# KITTITAS COUNTY

## DEPARTMENT OF PUBLIC WORKS

**TO:** All Staff  
**FROM:** Public Works Plan Review Team  
**DATE:** September 5<sup>th</sup>, 2023  
**SUBJECT:** SX-23-00017 McNeeley

SITE PLAN

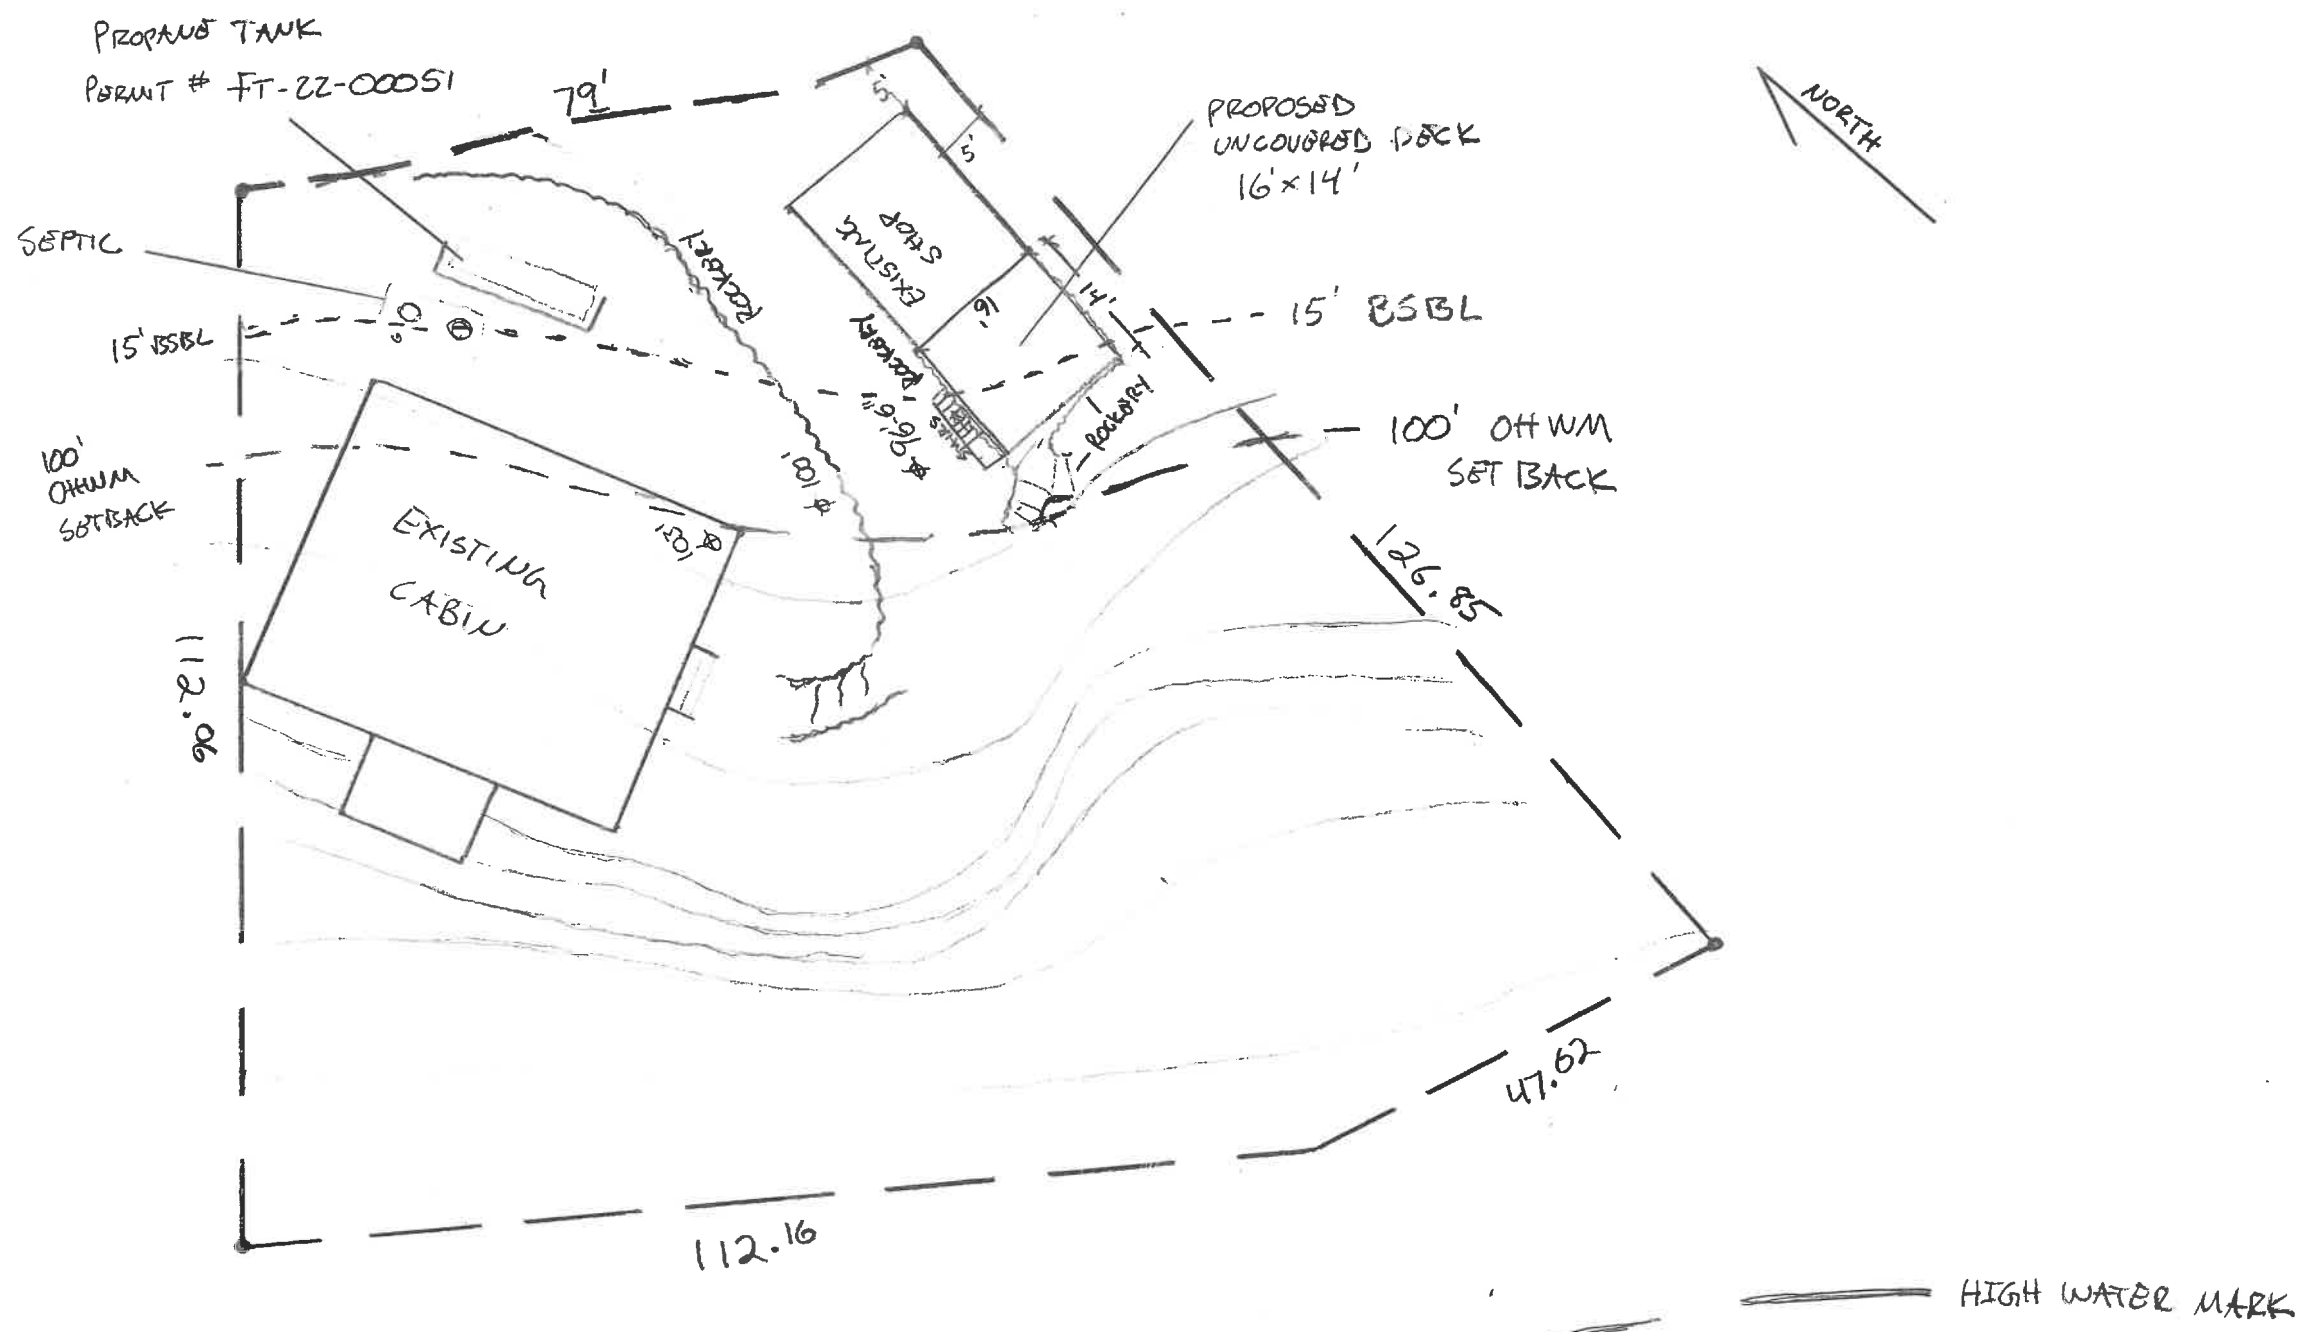
<b>ACCESS</b>	No Comments (TM)
<b>ENGINEERING</b>	No comments (JF)
<b>SURVEY</b>	<ol style="list-style-type: none"><li>1. The provided site plan does not address all the required information per page 1 of the application. (driveway/well/replacement septic/etc.)</li><li>2. Setbacks should be addressed by CDS. If 5' setbacks are the minimum, suggest the limits be staked by a professional surveyor due to tight tolerances. (JT)</li></ol>
<b>FLOOD</b>	FEMA has mapped a portion of the property within the 100-year floodplain. The proposed activity is outside this mapped floodplain. A floodplain development permit is therefore not required for the activity seeking shoreline exemption permitting (AT).
<b>WATER MITIGATION/ METERING</b>	No Comments (AT).
